**EAST
CAMBRIDGESHIRE
DISTRICT COUNCIL**
THE GRANGE, NUTHOLT LANE,
ELY, CAMBRIDGESHIRE CB7 4EE
Telephone: [REDACTED]
[REDACTED]
[REDACTED]

Date: 7 November 2022

RE: Application by Sunnica Ltd for an Order Granting Development Consent for Sunnica Energy Farm Project – Written Representation Deadline 2

Drawing Title  
**FIGURE 10-14C  
 LANDSCAPE MASTERPLAN  
 SUNNICA EAST SITE B**

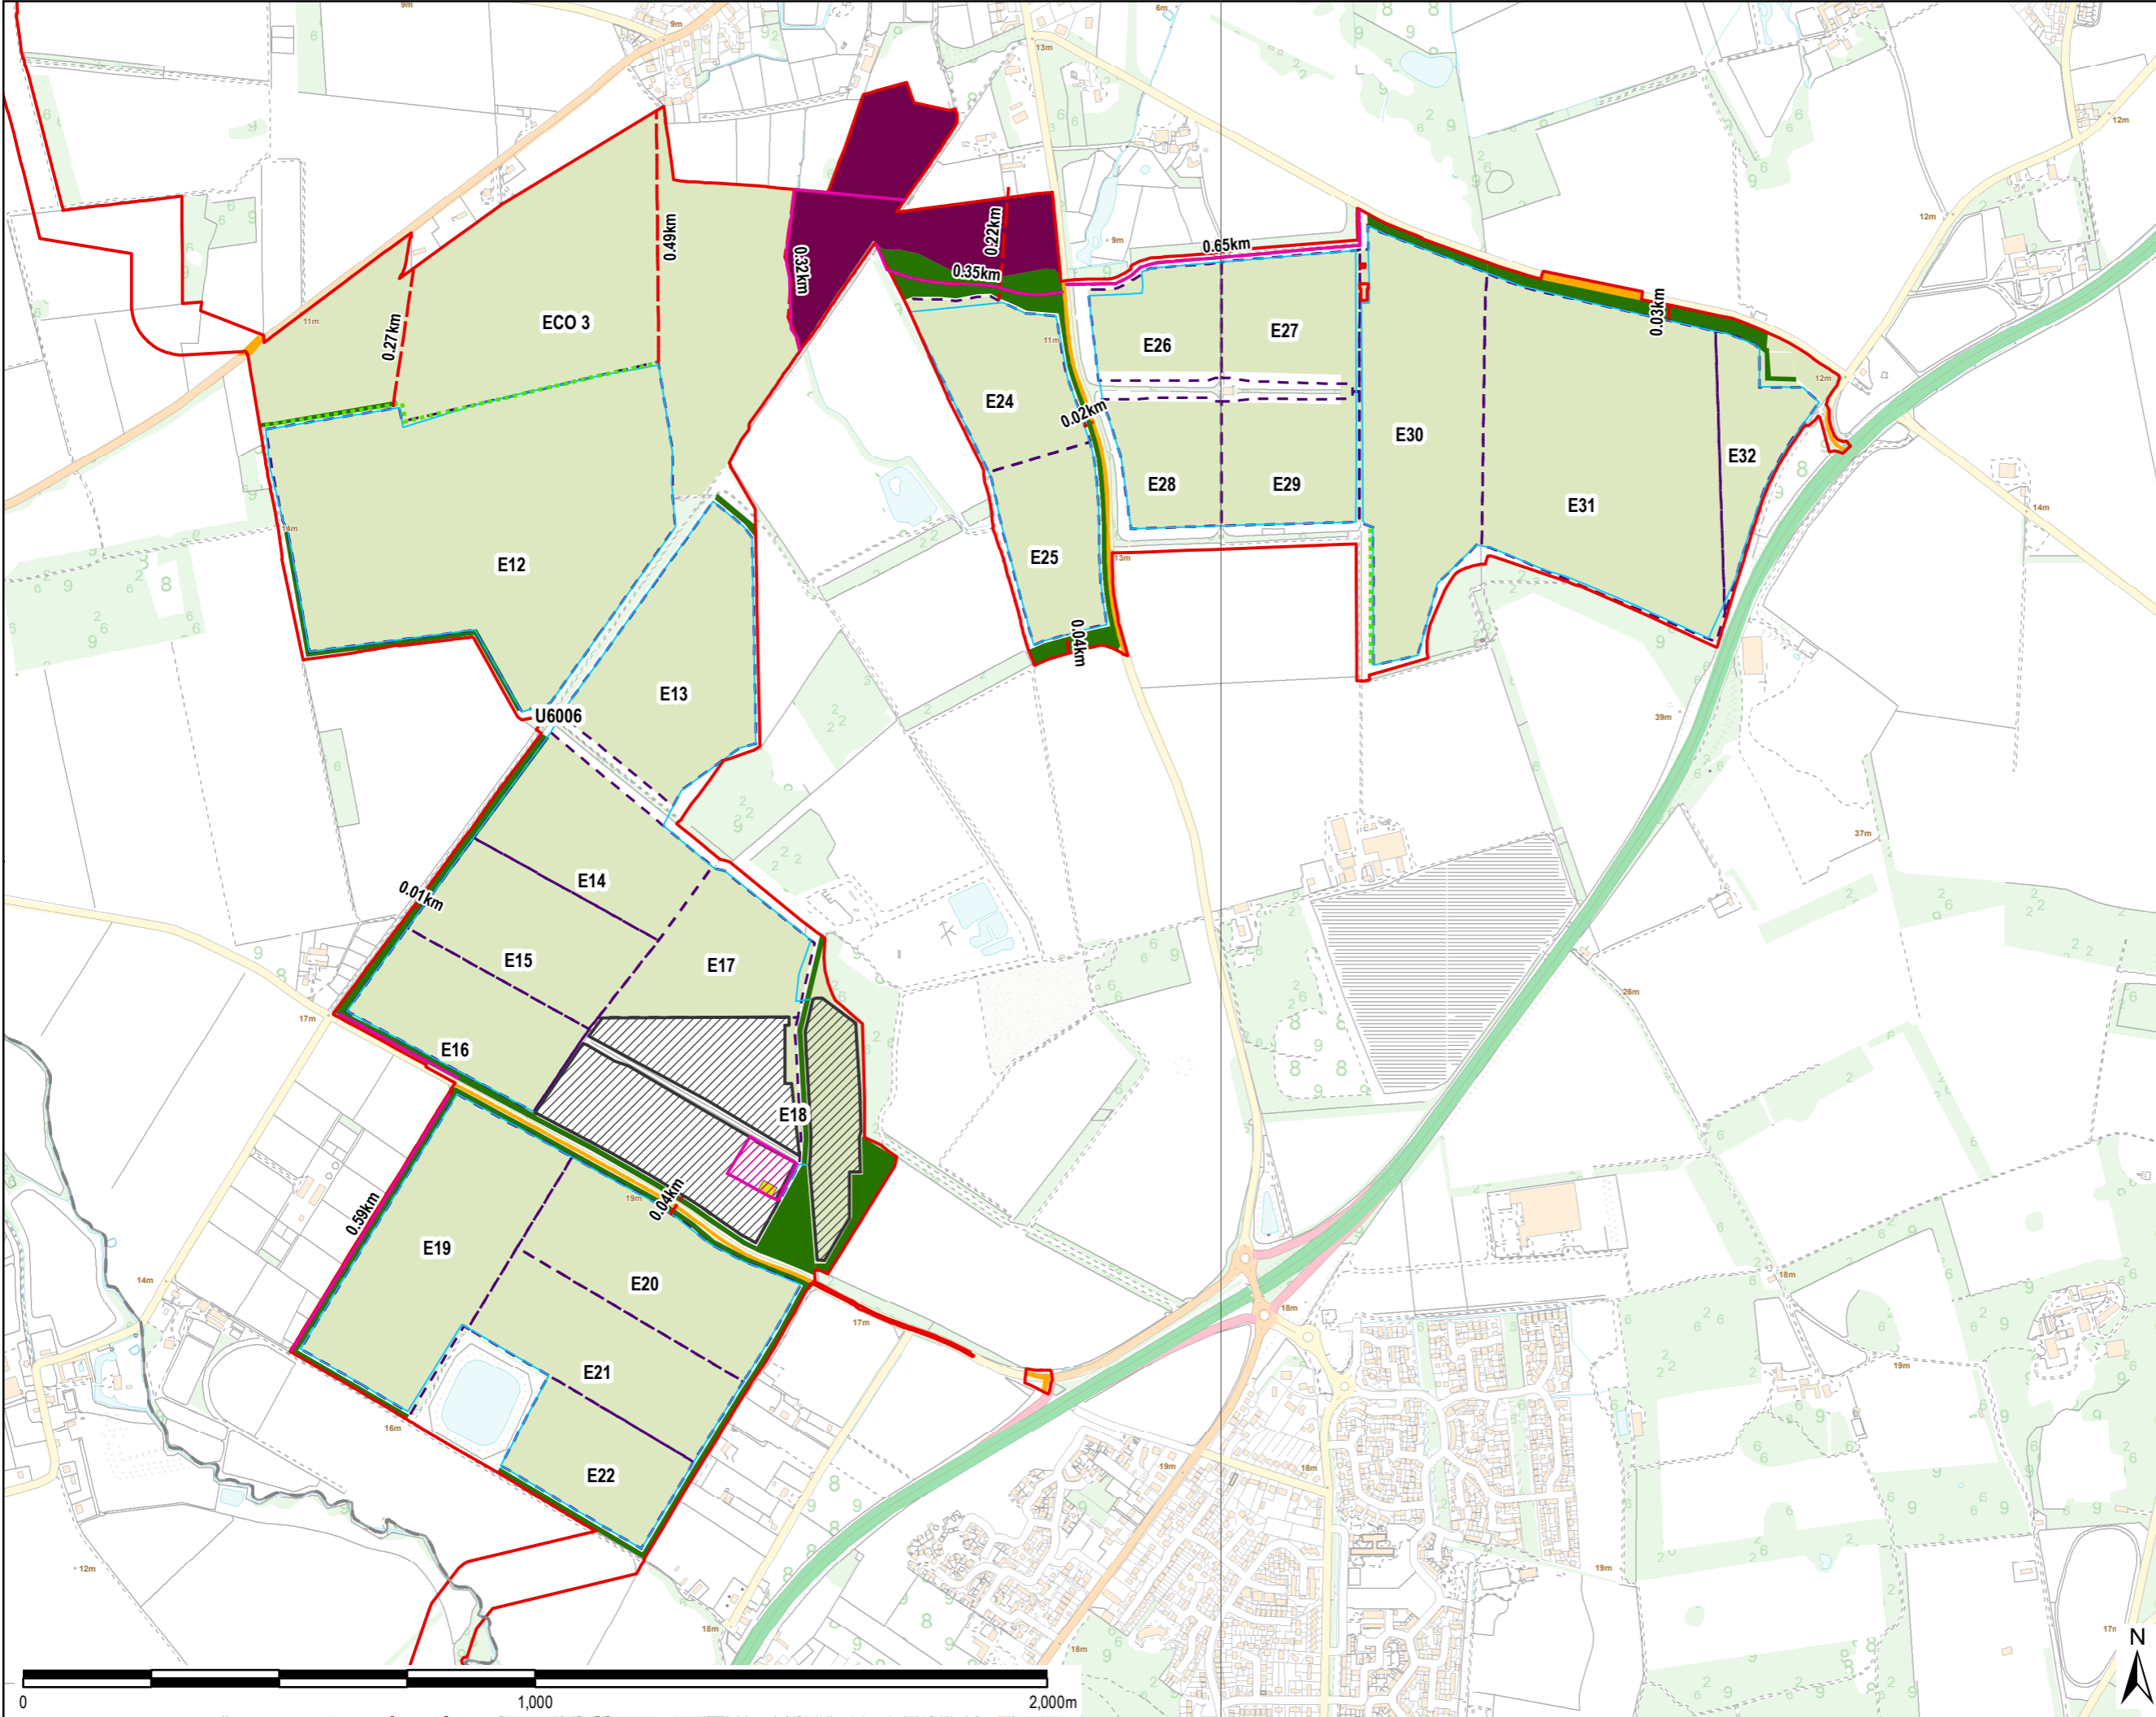
However, given the size of the Scheme, the period of time it will be in situ, its overall poor quality, the detrimental harm to the long term landscape would not be outweighed by the benefit of renewable energy. The following sections of the development should be removed from the development as a landscaping scheme would not mitigate against the long term harm:

- E05
- W03 – W12

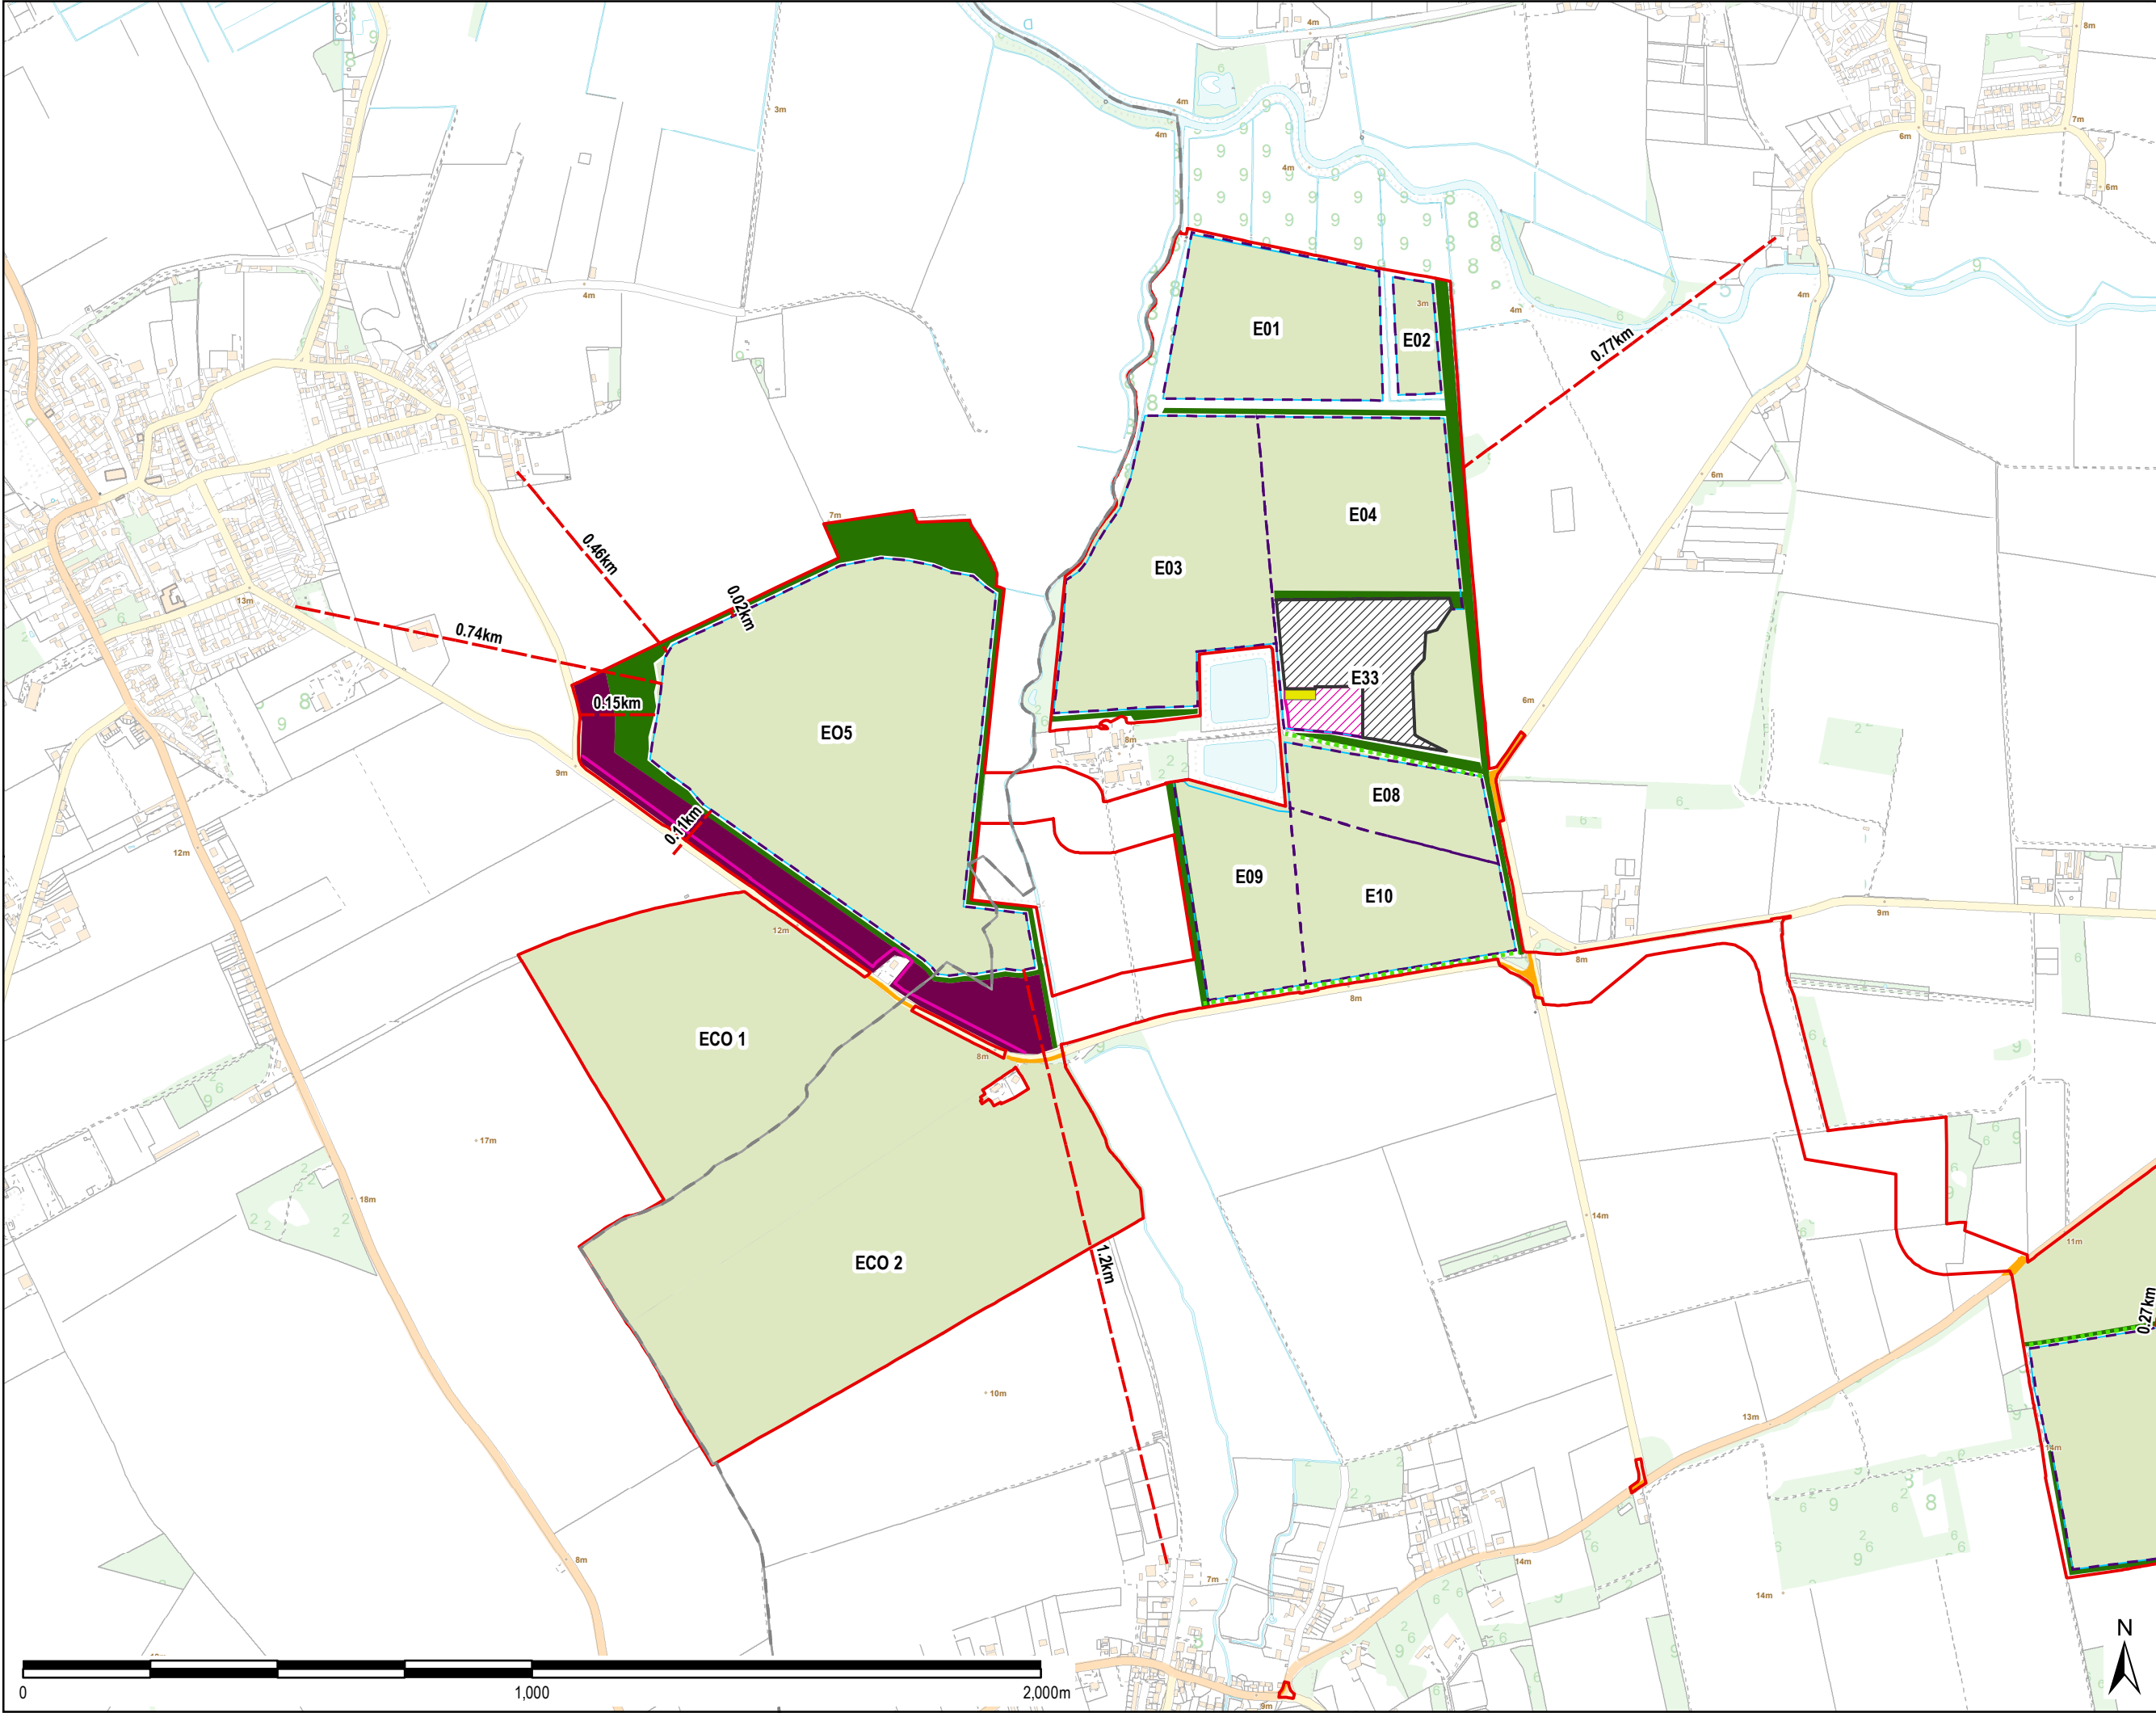
It is considered that the developer has failed to provide adequate reports or understanding of the potential impact on biodiversity within the local area/development site. Specifically it is recommended the following parcels should be removed from the development as this would

lead to the long term detrimental harm to biodiversity within the district to Chippenham Fen (Ramsar and SSSI) and Snailwell Meadows (SSSI):

- W01-W02
